Application no: 23/00651/DISC

Location: Begbroke Science Park, Begbroke Hill, Begbroke, OX5 1PF

Transport Development Control

Proposed Street Furniture - Supporting Images

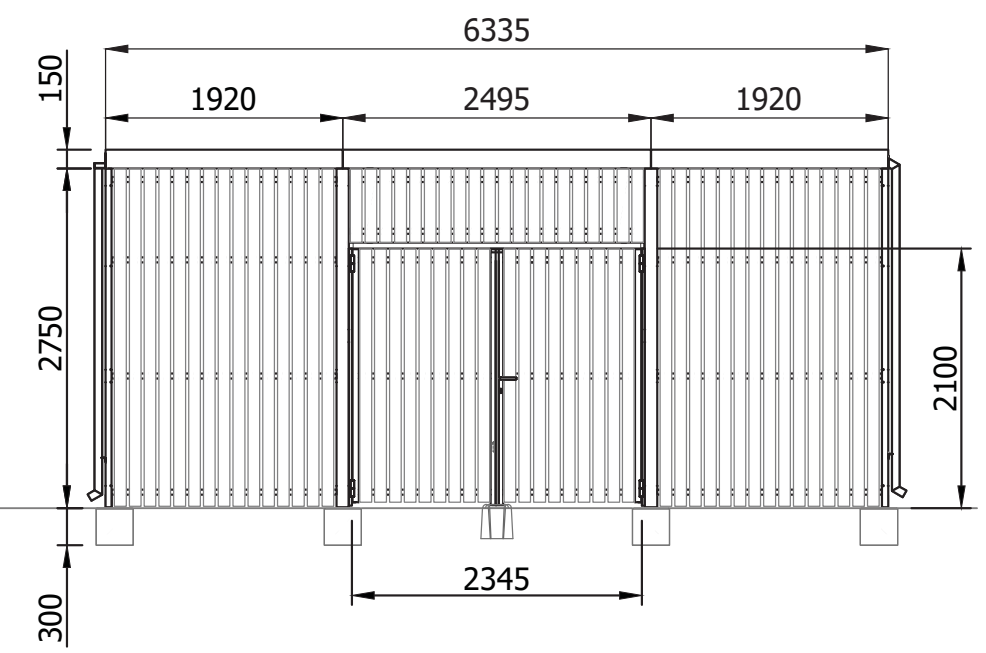
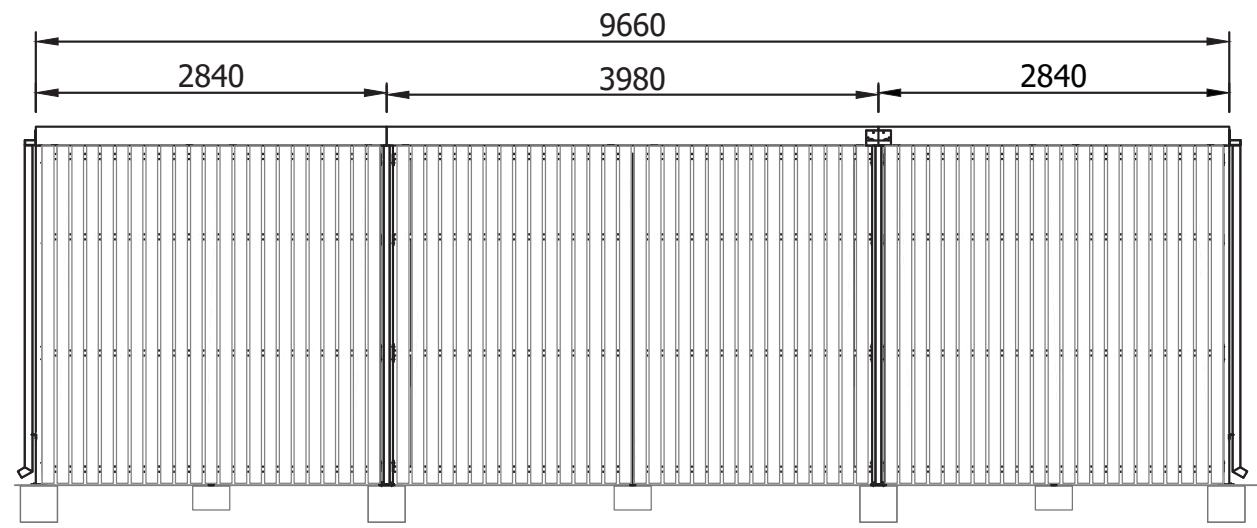
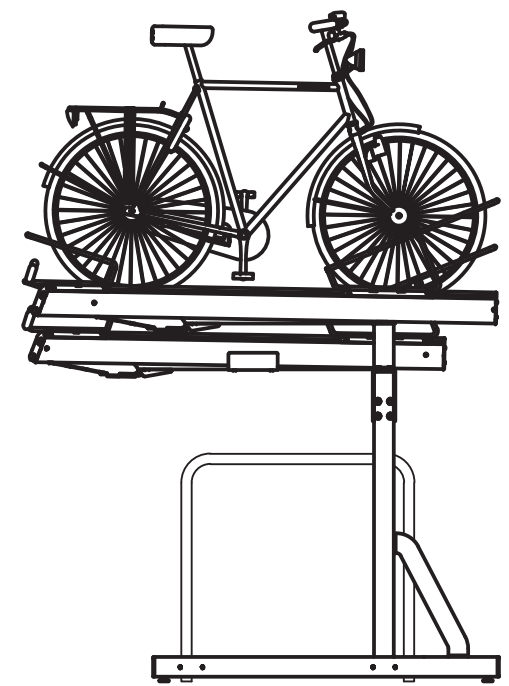
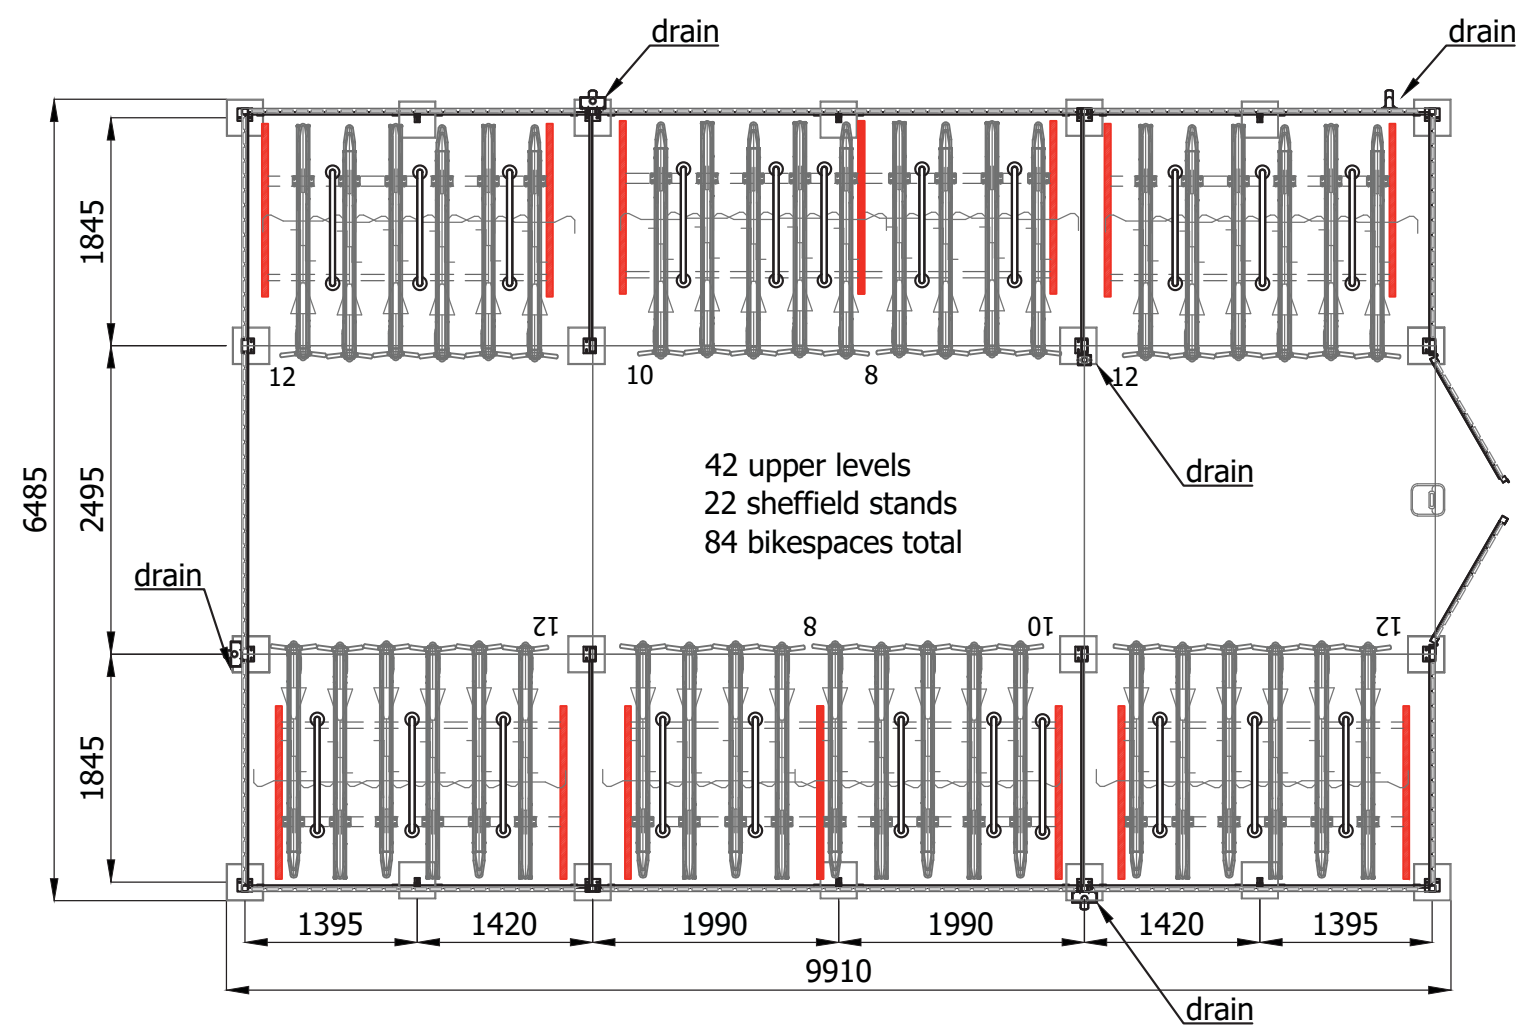
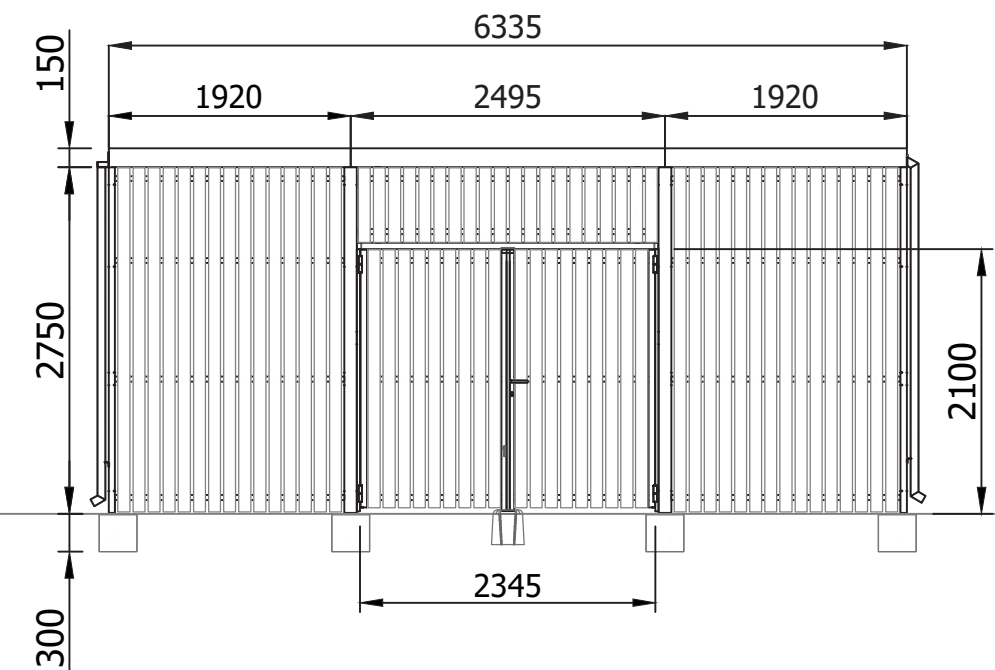
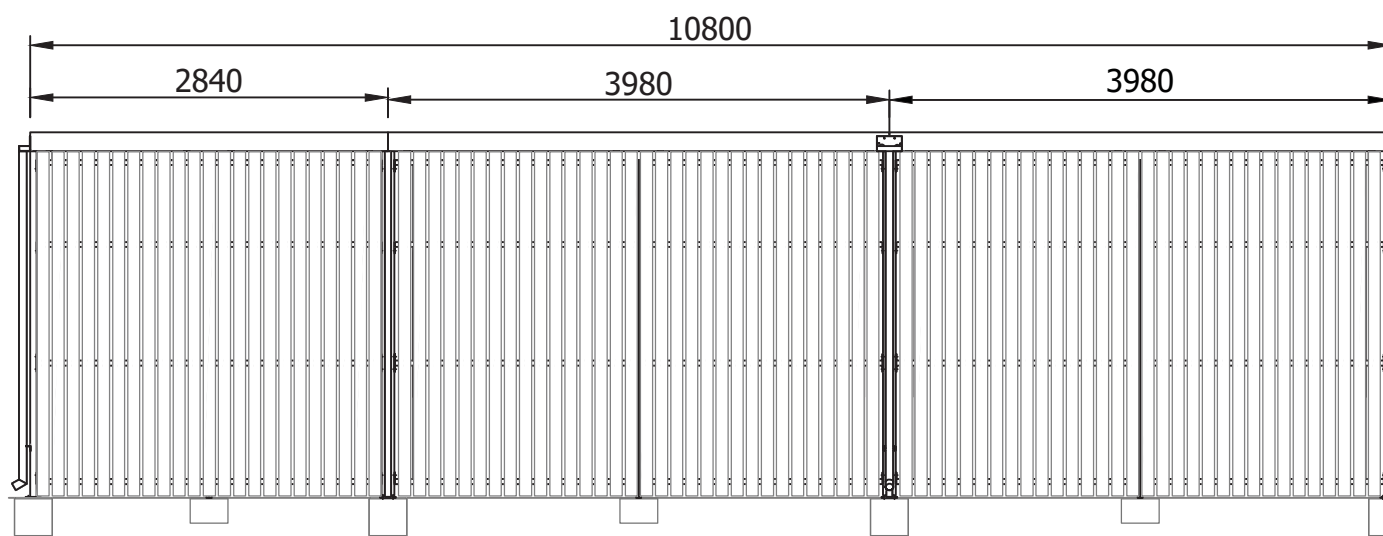
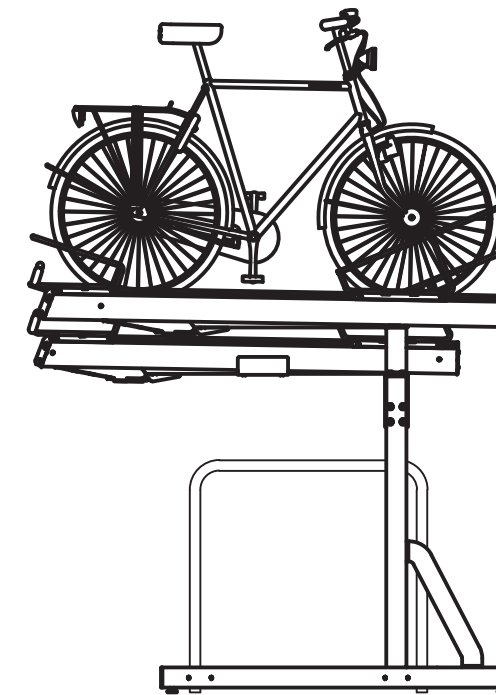
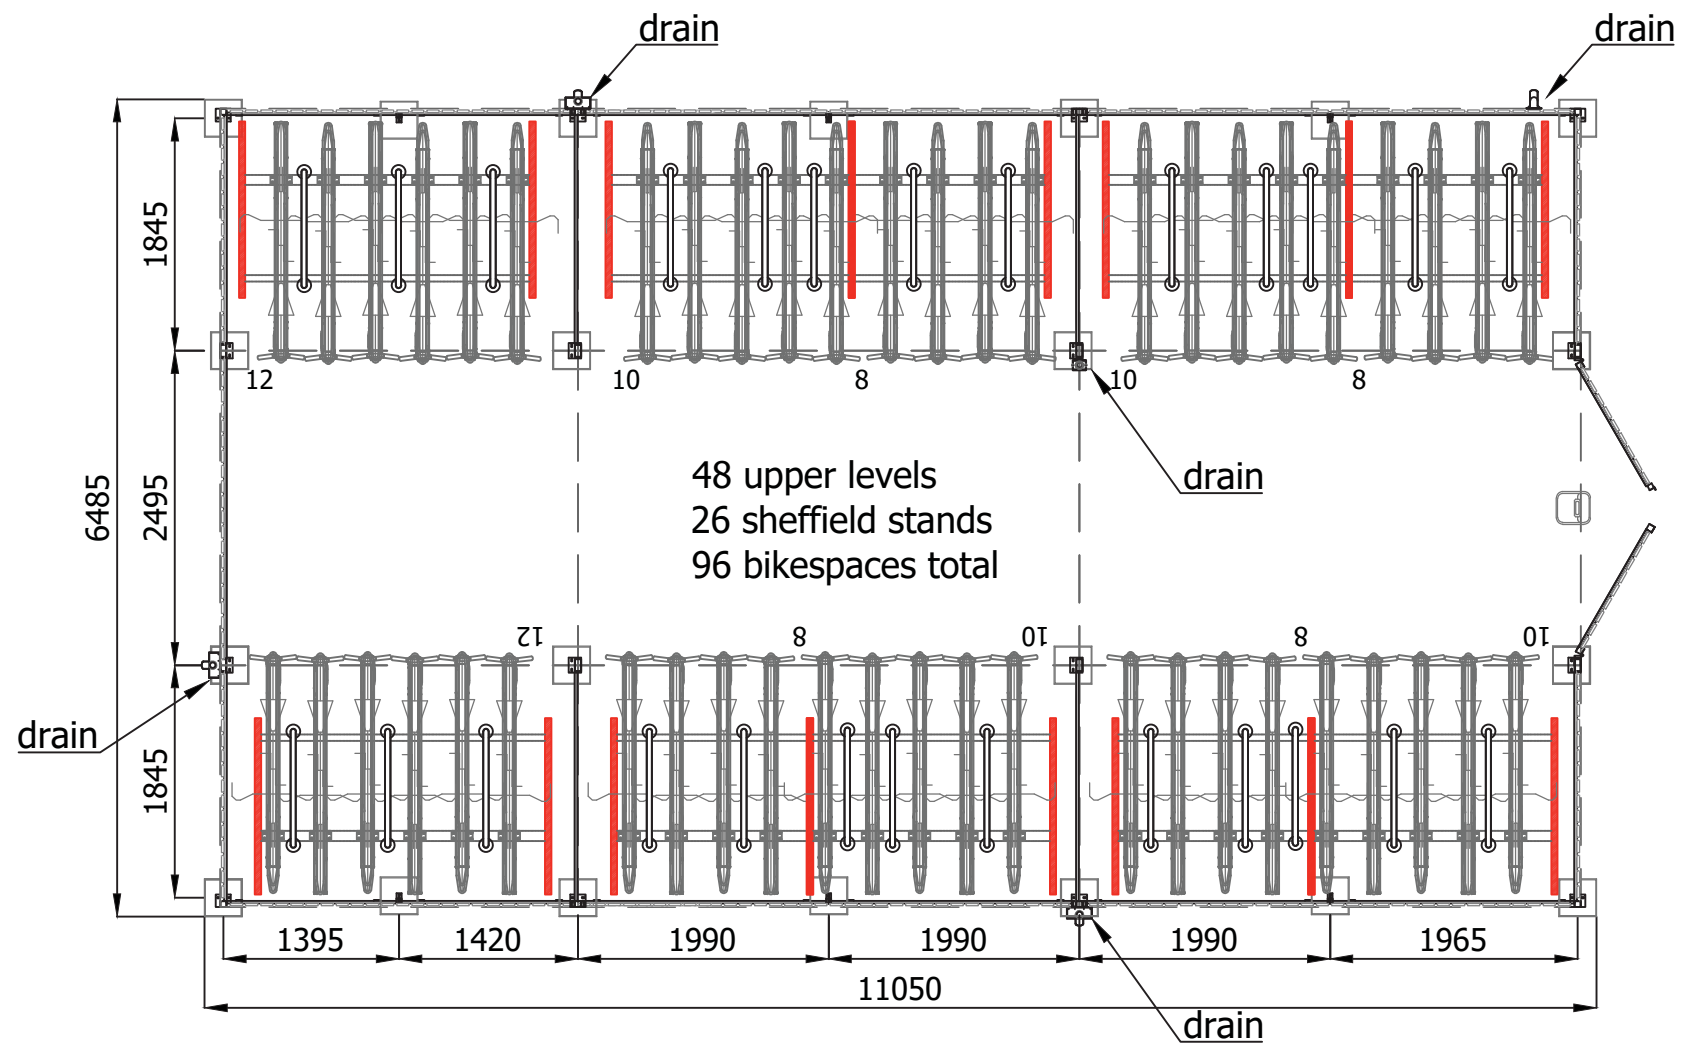
Oxfordshire County Council's adopted Parking Standards advise against the use of tiered cycle parking facilities as raising or lowering bikes to / from the top tier can be very difficult for some people, particularly with heavy bikes such as e-bikes which are becoming increasingly popular.

However, I note that the majority of spaces are provided through the use of Sheffield stands. The number of Sheffield stands available across the site is sufficient to accommodate the minimum number of cycle parking spaces required under Oxfordshire County Council's Parking Standards, and therefore the tiered parking spaces can be seen as supplementary to these spaces.

drawing title:
Landscape Masterplan
Car & Cycle Parking Arrangement

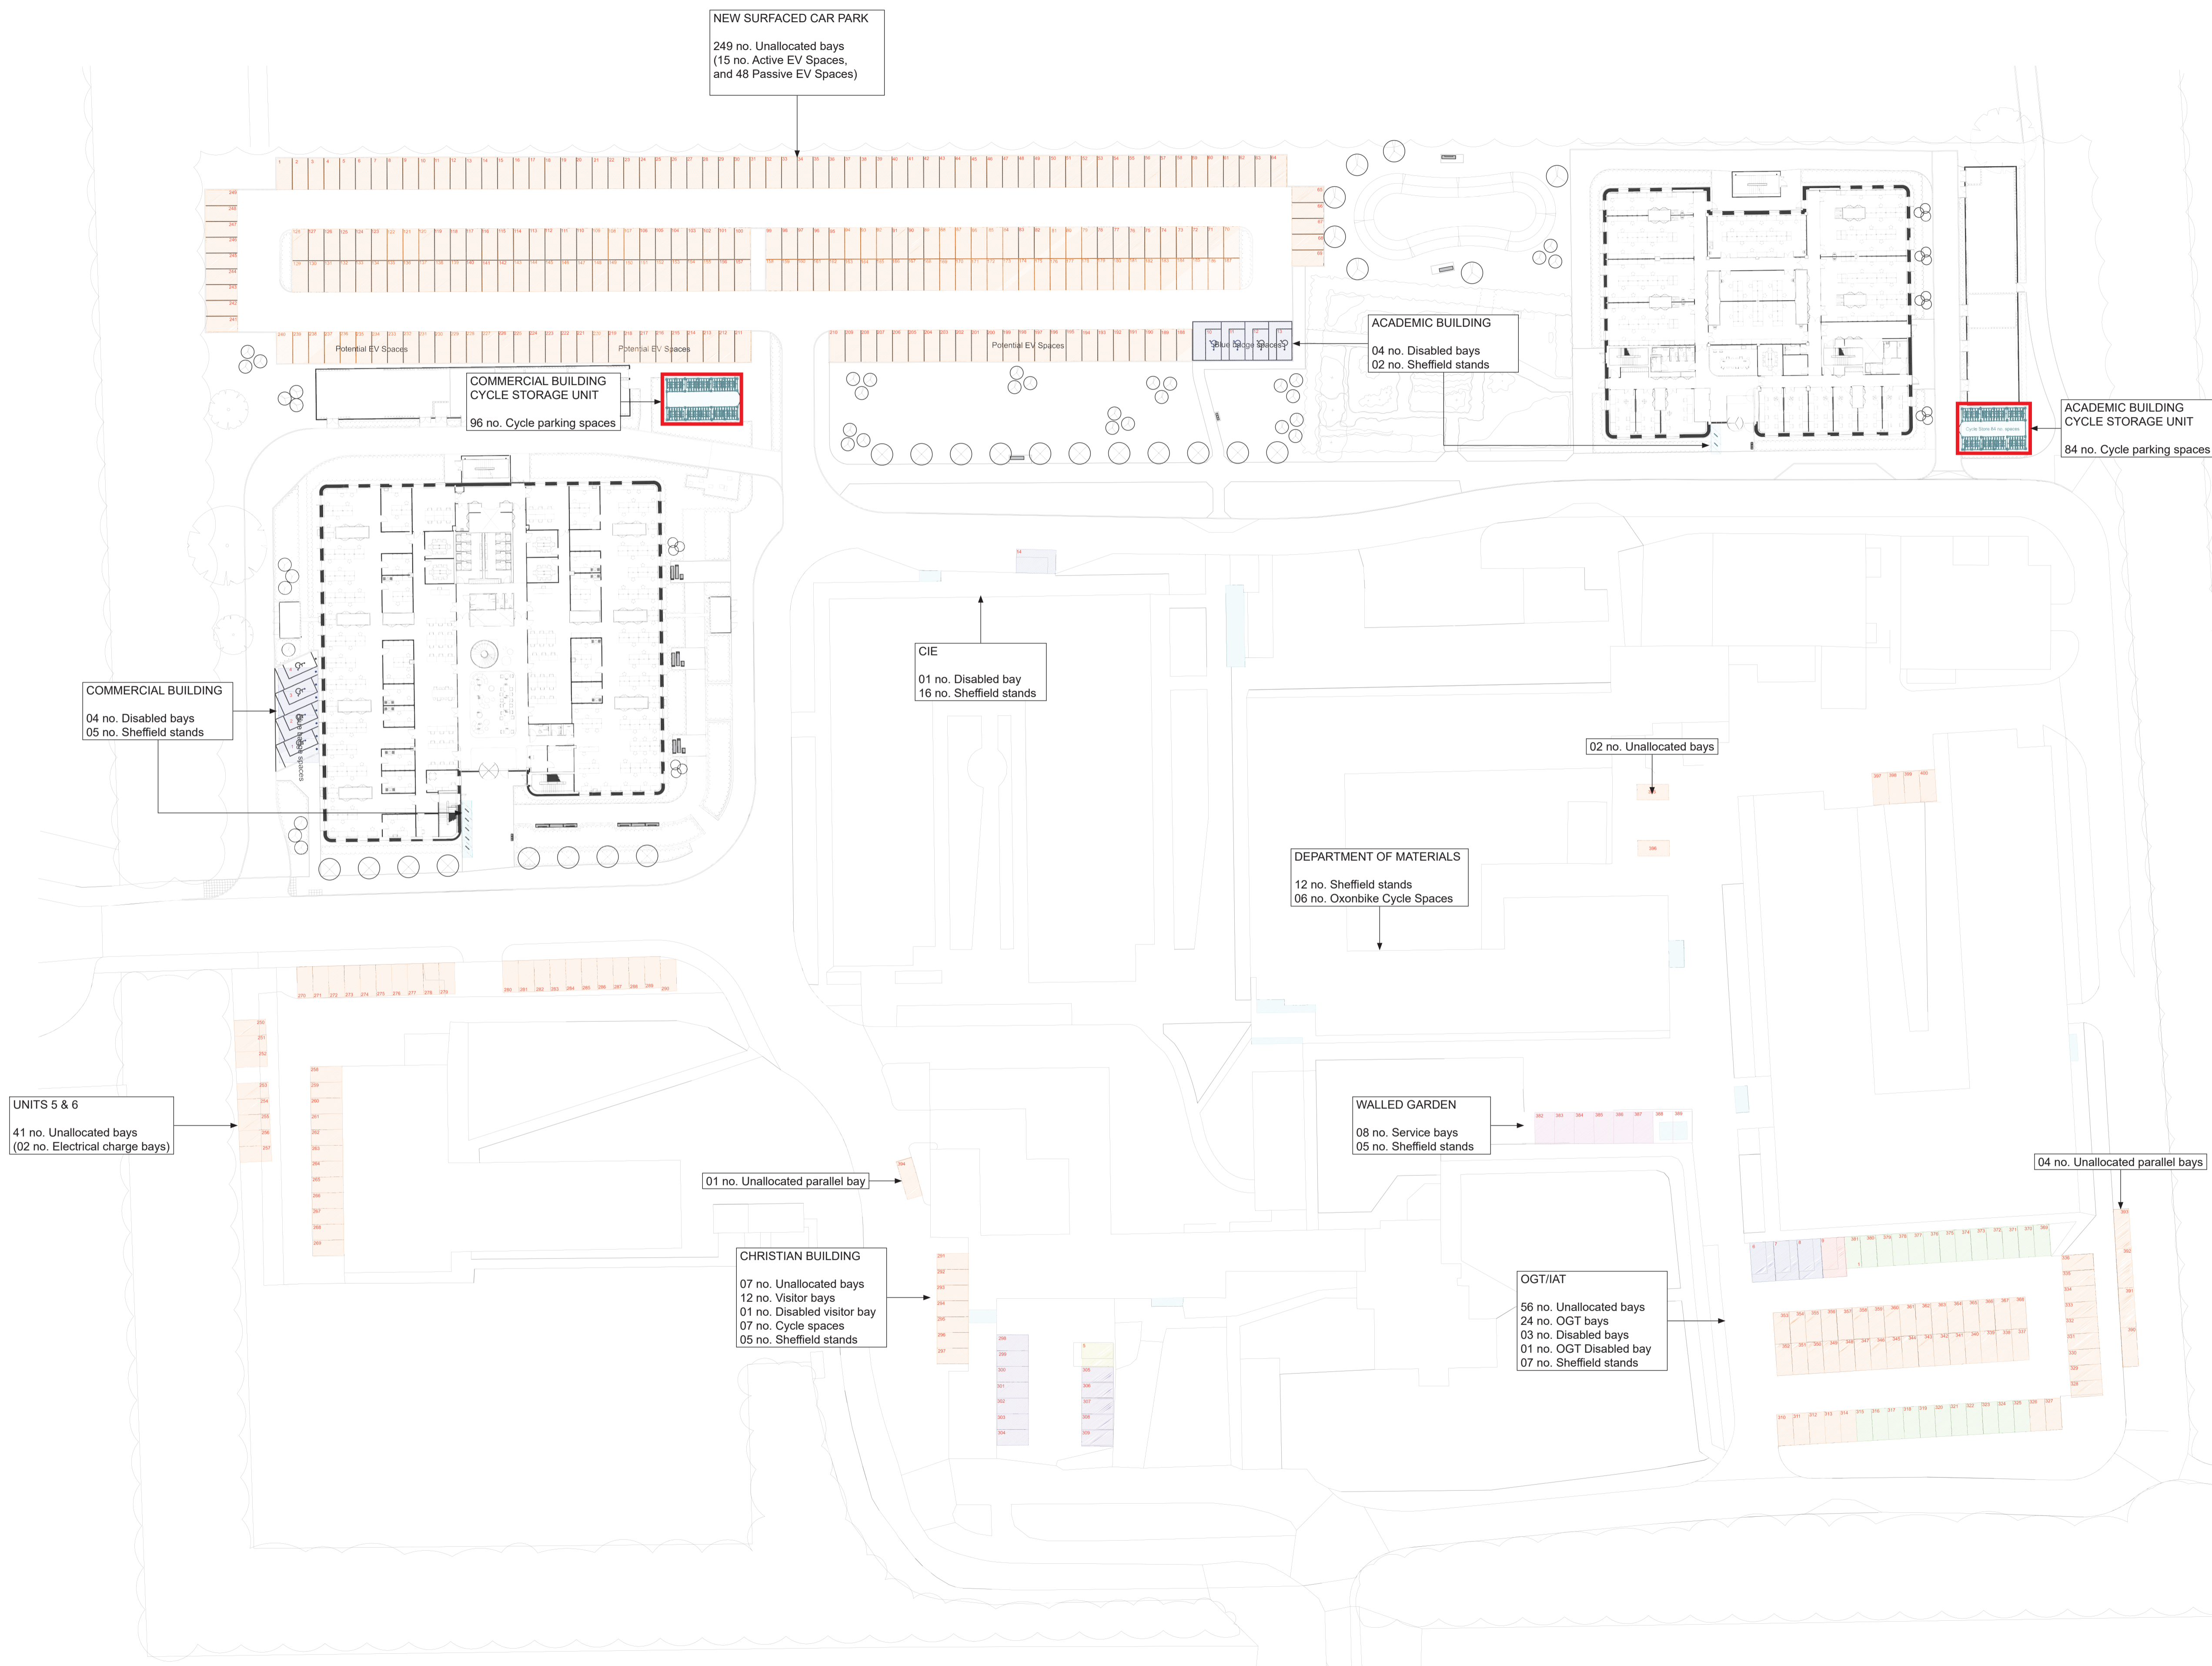
The cycle parking appears to be suitably located for access and convenience, and therefore the County Council does not object to the application of discharge condition 19.
